# APPLICATION BY NATIONAL HIGHWAYS FOR AN ORDER GRANTING DEVELOPMENT CONSENT FOR THE A66 NORTHERN TRANS-PENNINE PROJECT

Submission on behalf of Cumbria & Lakes Joint Local Access Forum in accordance with Deadline 1 (18 December 2022).

Drawing Title  
**Land Plans  
Regulation 5(2)(i)  
Sheet 3 of 4**

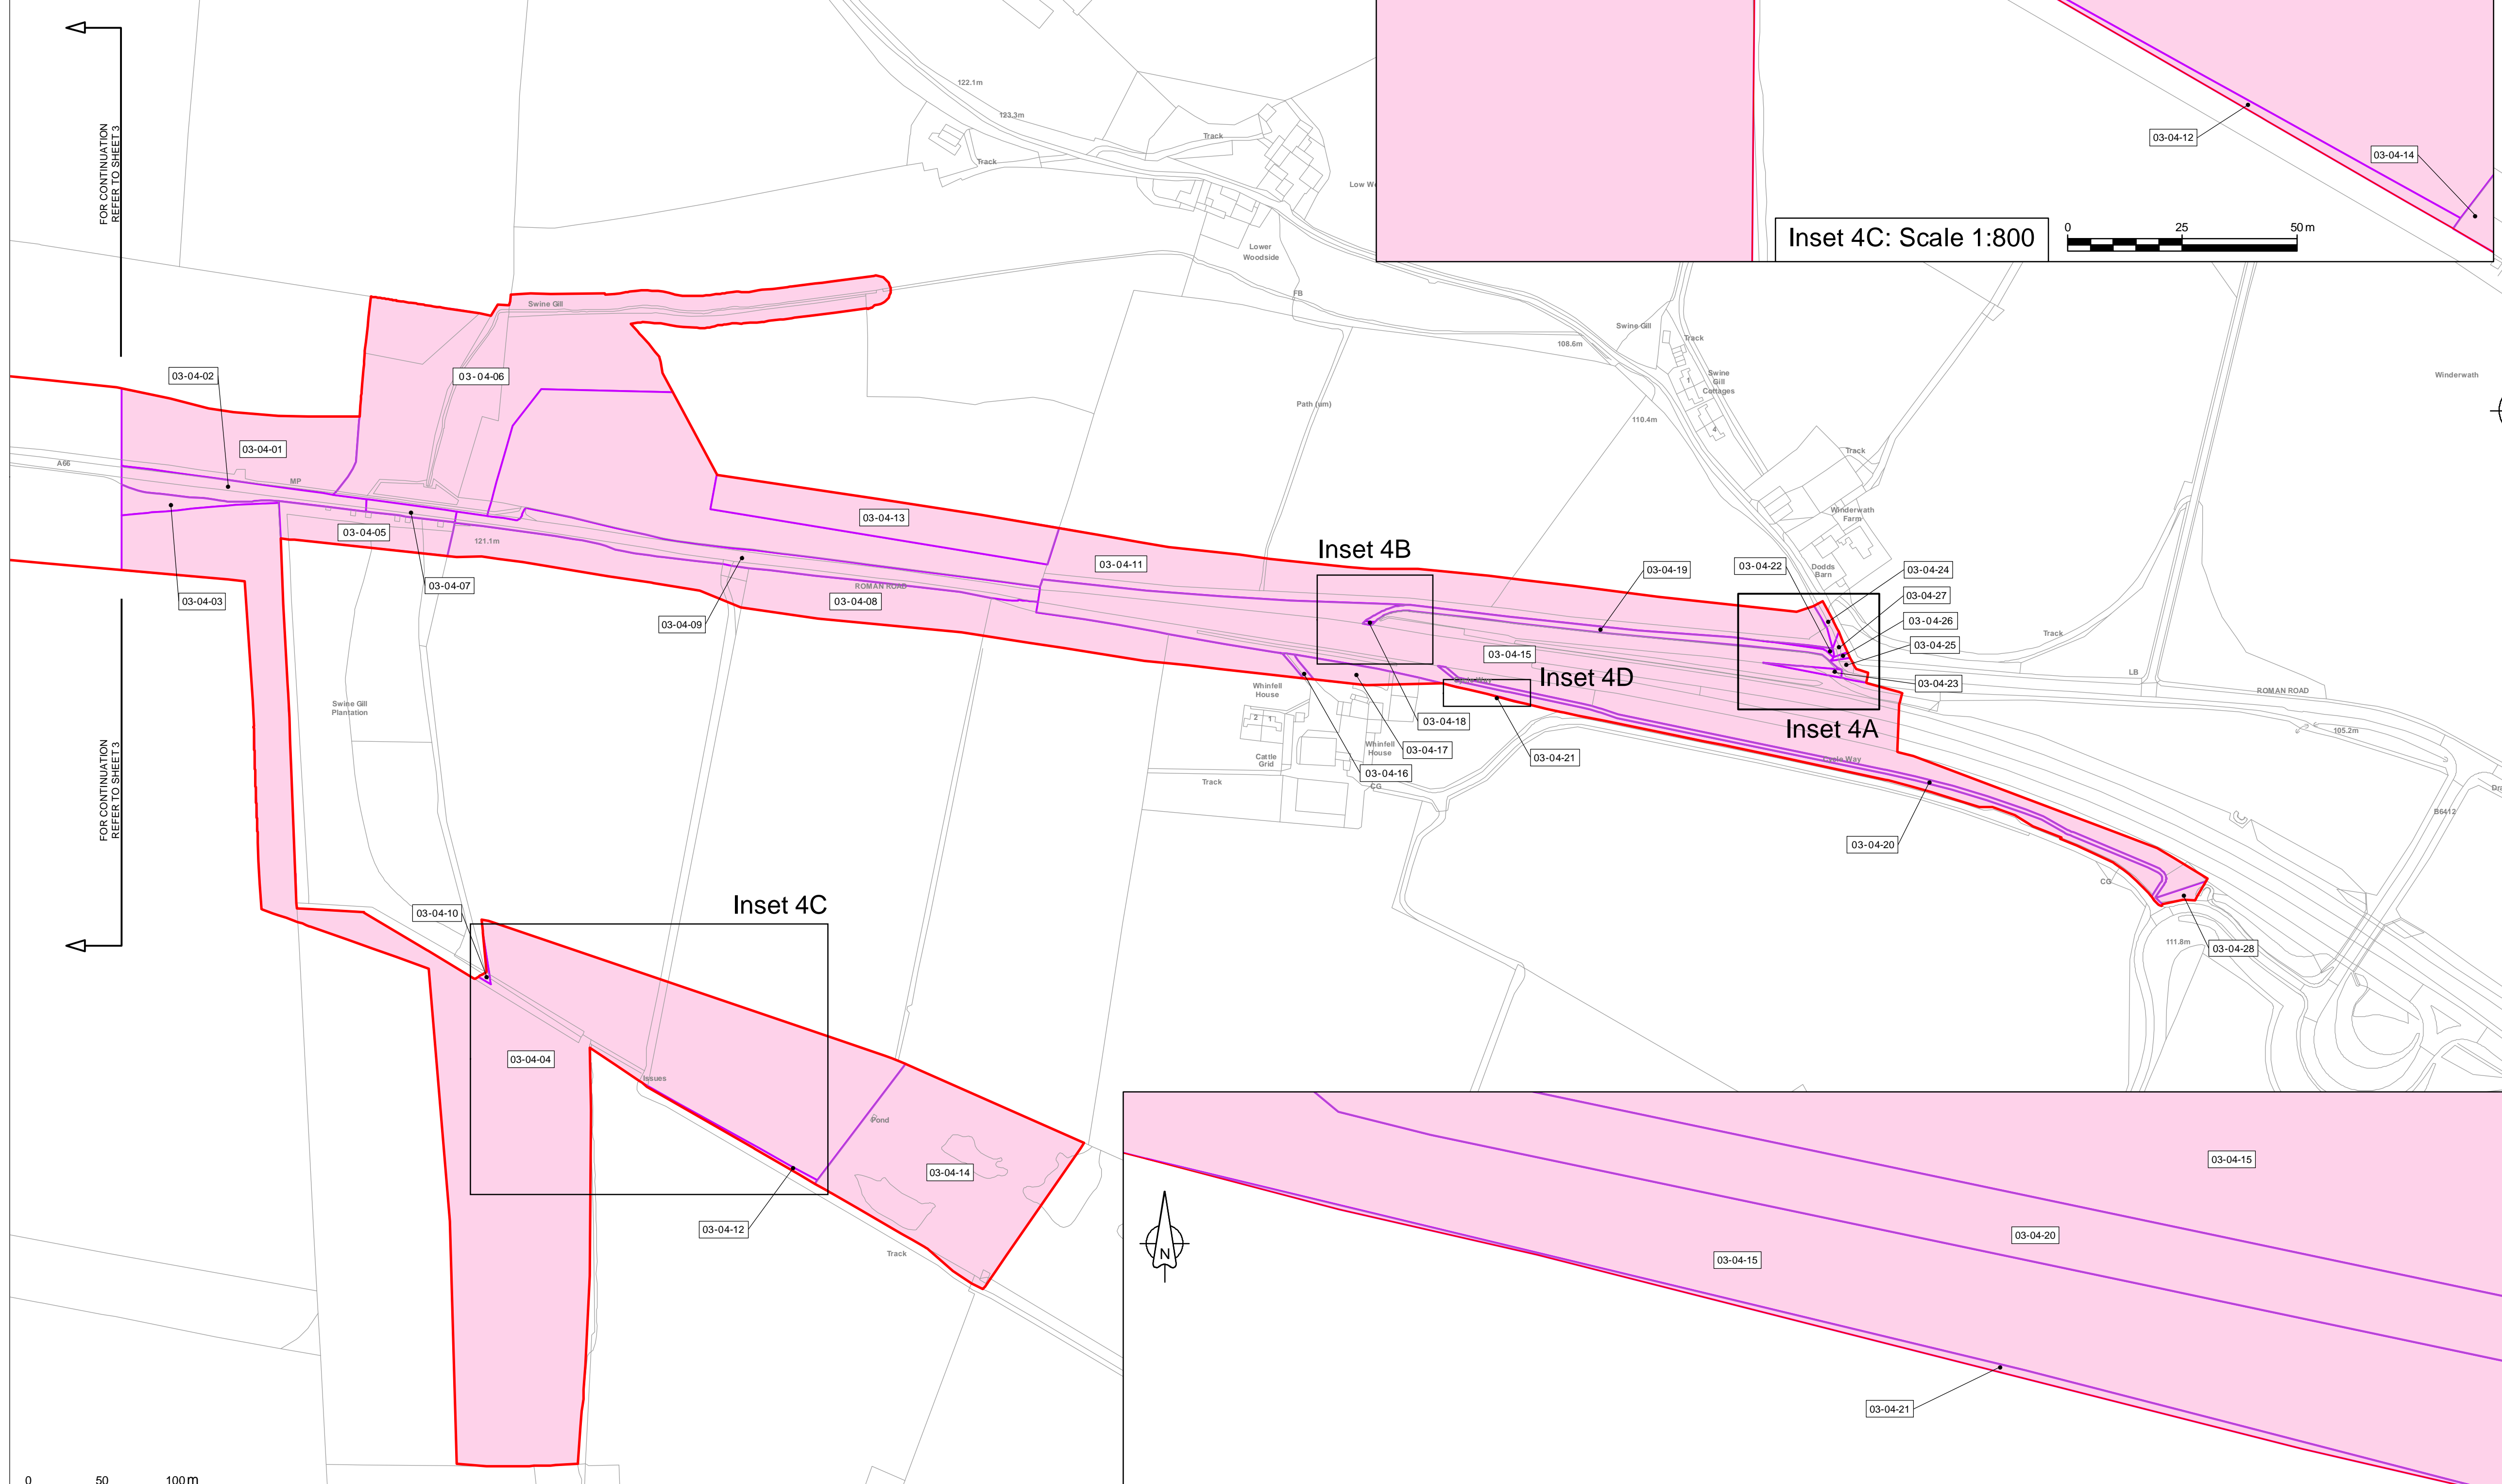
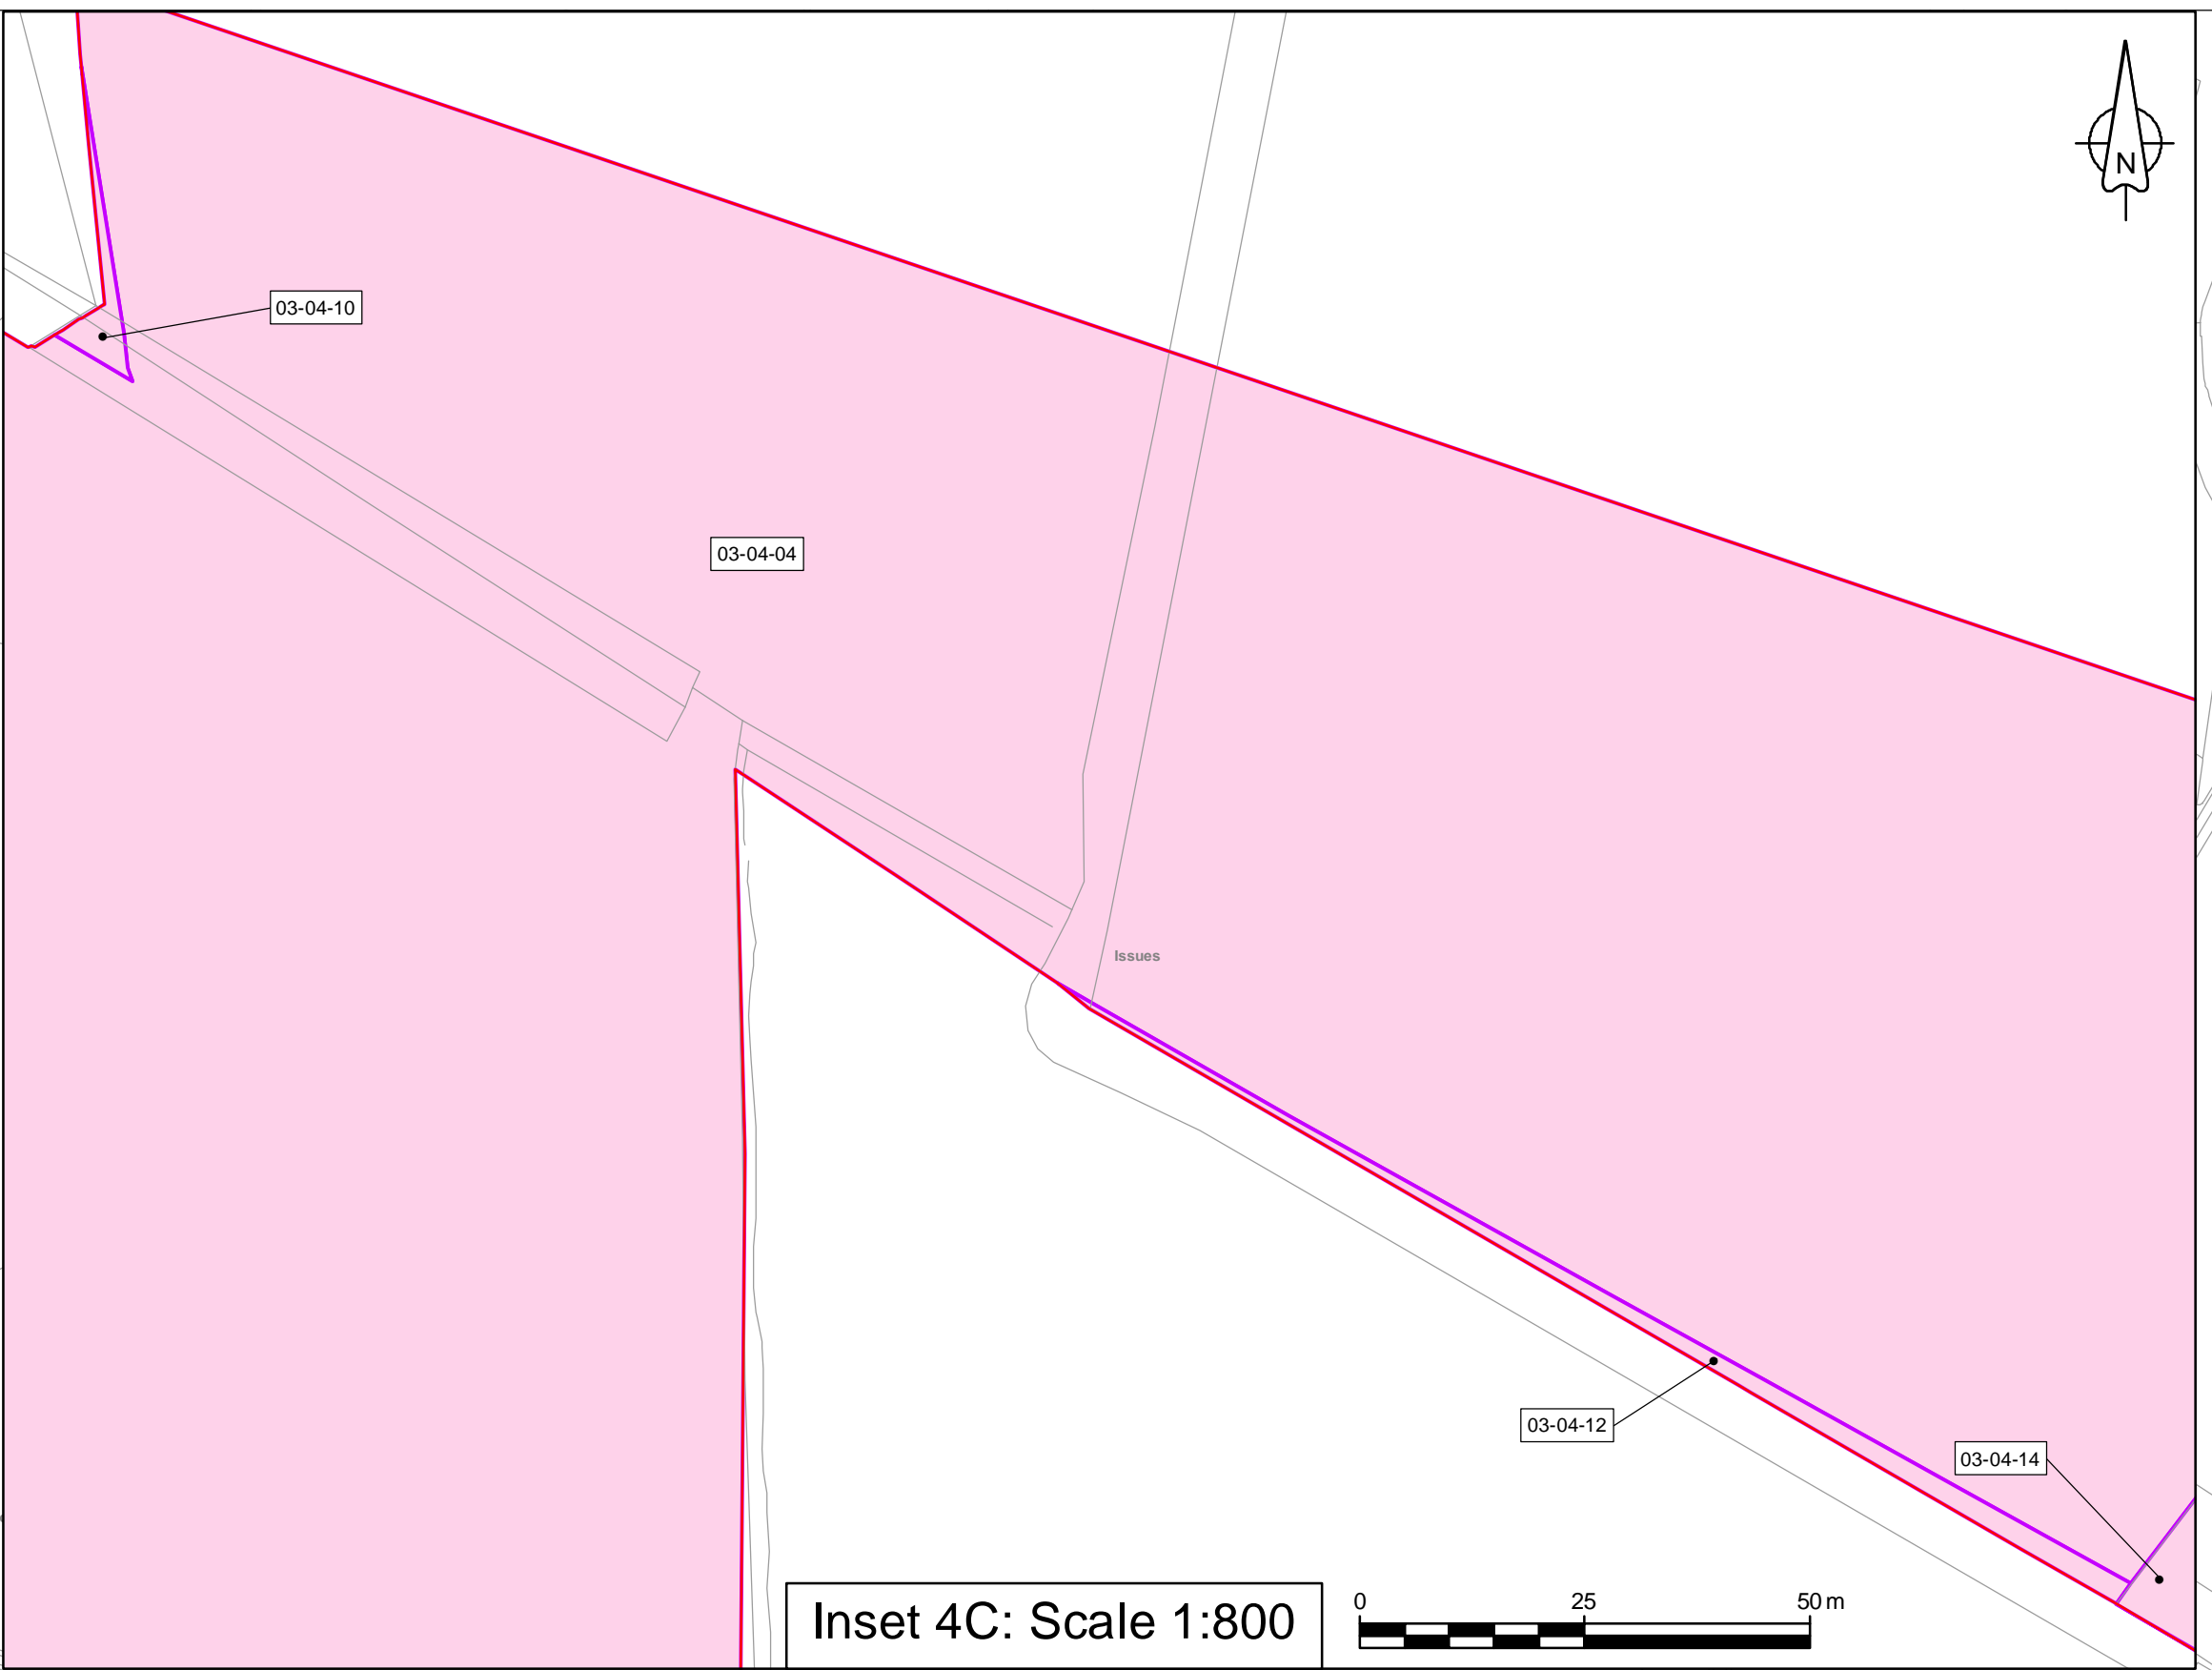
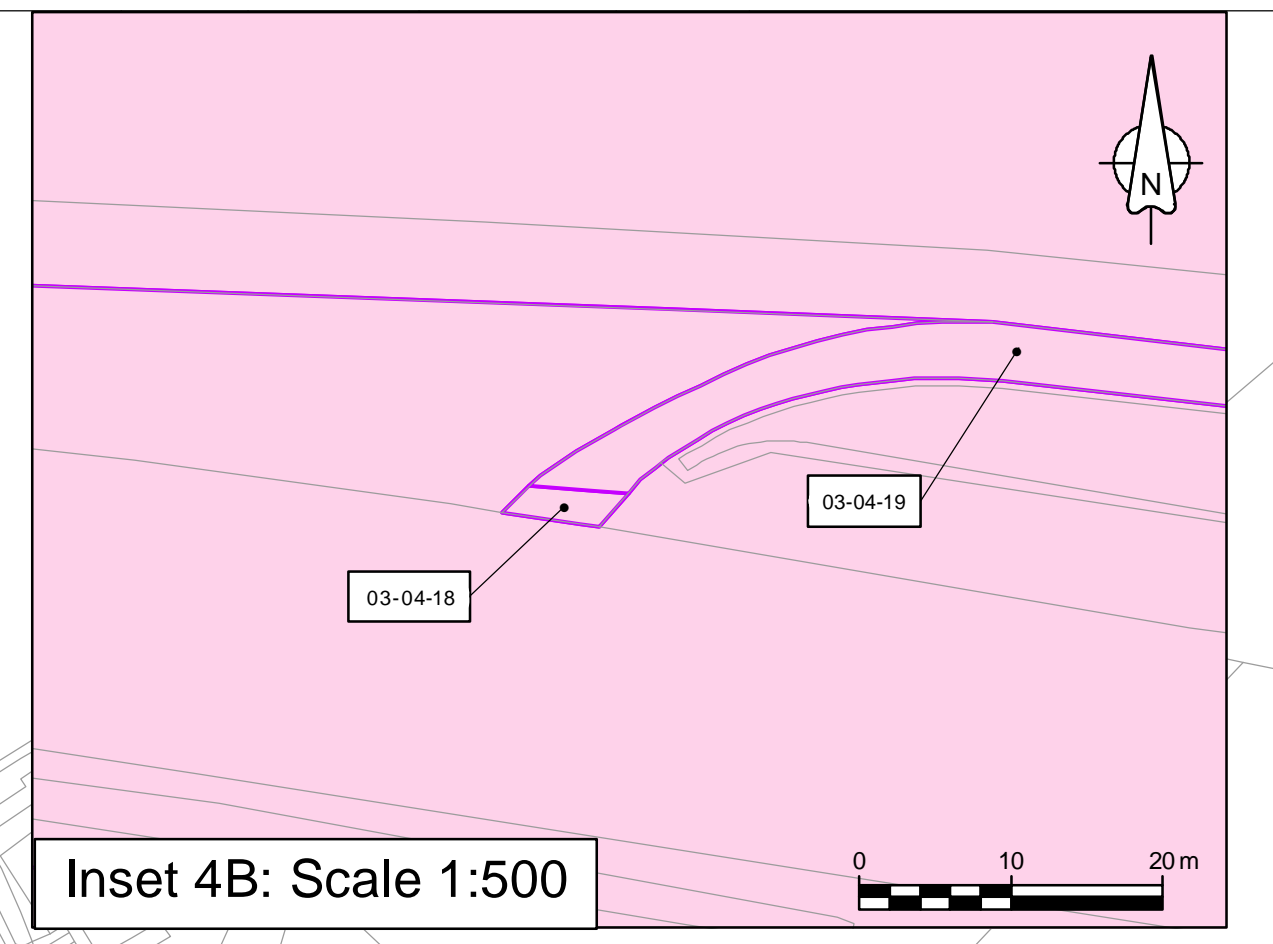
- 9.3 On sheet 3 of scheme 3 there appears to be an error in the description of A\* which refers to a 'shared cycleway' with references to High Barn which possibly are wrongly orientated. And what happens at B\* where there is a section or 'shared cycleway' with no notation.
